10 June 2015

Crown Sydney Property
Attn: Daniel Prince
Level 3, Crown Towers
8 Whiteman Street
Southbank, Victoria, 3006

Re: Interim Audit Advice, Addendum to Remedial Action Plan, Crown Hotel Development (Part of ORWN Area), Barangaroo South

Figure 2

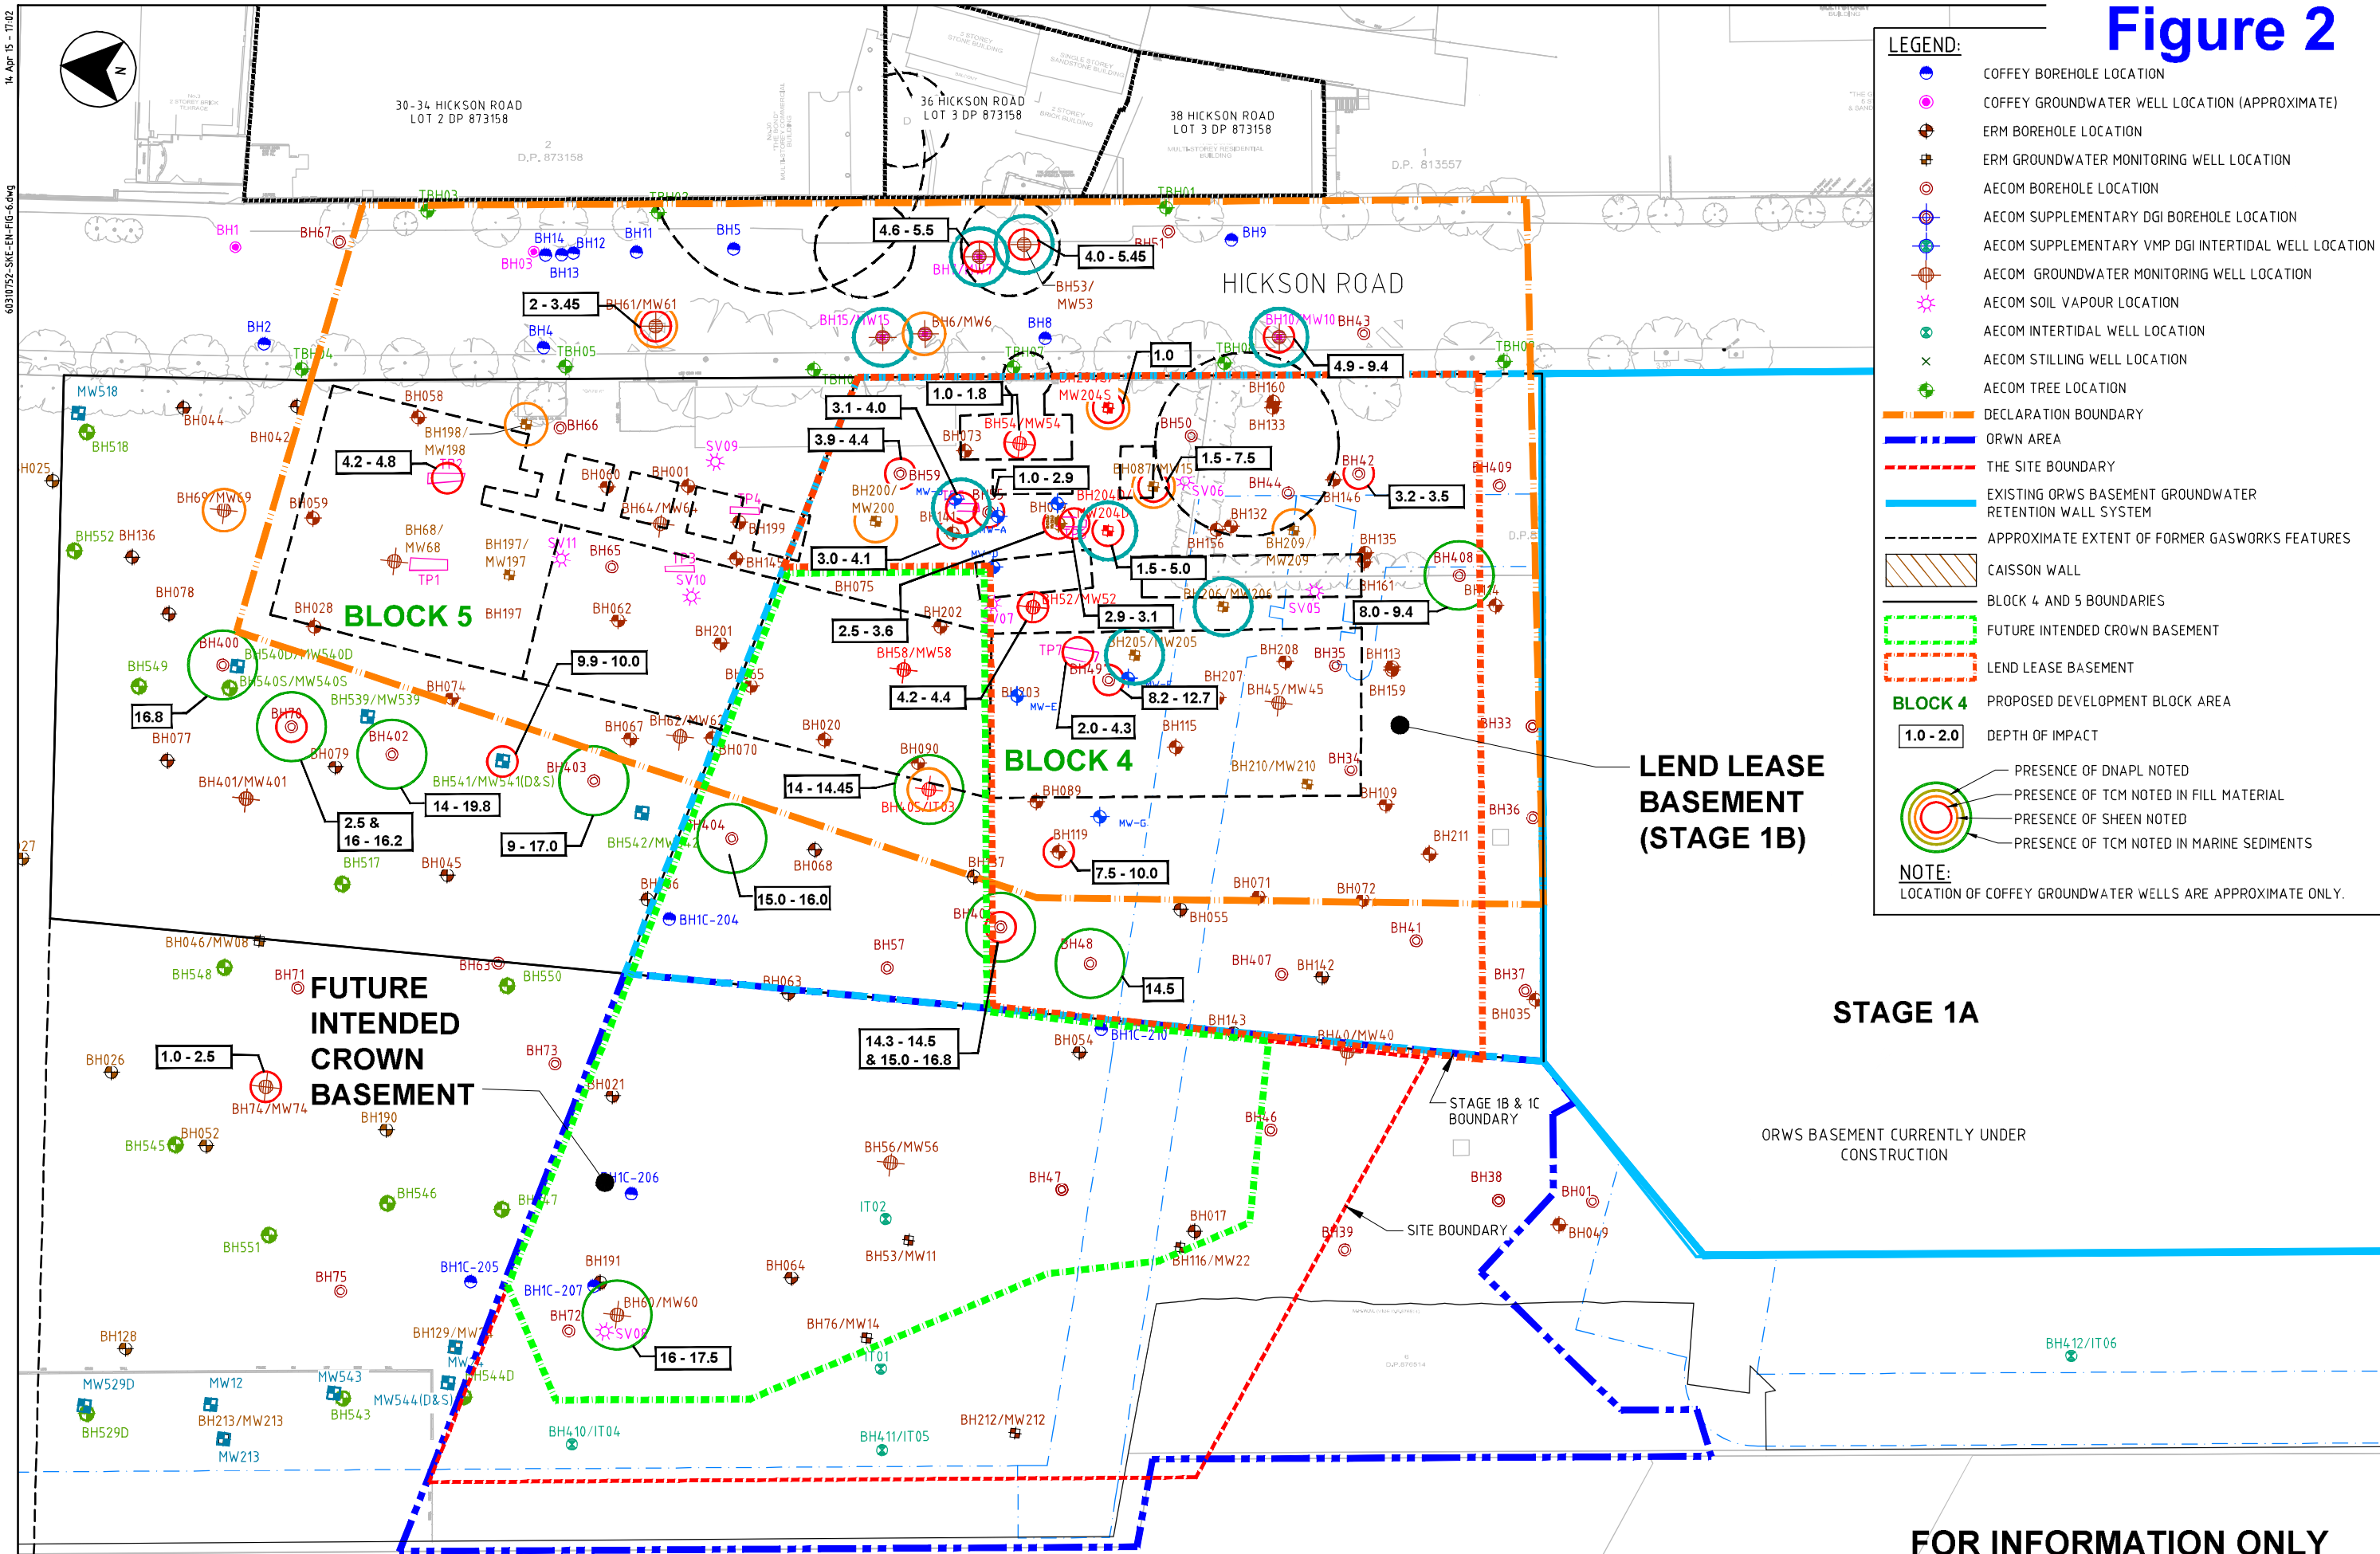
This conclusion is further supported by additional information made available to AECOM since completion of the Crown RAP and documented in the RAP Addendum. Lend Lease identified a significant volume of bonded ACM during shallow excavation works required for a new sewerage pump out pit within the site. The pit was constructed for a New Amenities Area associated with the construction compound supporting the adjacent Stage 1A development works. Lend Lease estimated that the excavation measured approximately 3 x 3m and 2m deep. Lend Lease reported that between 20 and 30 bonded ACM fragments were observed in the small stockpile formed from this excavation and that the fragments measured in the order of 40 x 60mm x 6mm thick. The excavated material was added to stockpile SP225 which was classified as Special Waste (asbestos) for off-site disposal. Analysis of the fibre cement sheet fragments confirmed chrysotile, amosite and crocidolite asbestos to be present. Validation of the walls and base of the excavation was not undertaken. As such, it is likely that bonded ACM remains within the fill surrounding the excavation.

This area is shown on Attachment 2 and is identified as the initial remediation extent required to address ACM in soil. AECOM has recommended in the RAP Addendum that the additional delineation sampling of the soils in the unsaturated zone include gravimetric assessment of bonded ACM (per NEPM (1999)[2013], "asbestos quantification") to allow comparison with the SSTC for asbestos and to delineate the final extent of CIM that warrants remediation.

AECOM estimate that remediation will be required to a depth of approximately 2m below the final development level, and may be up to the depth of the unsaturated soil.
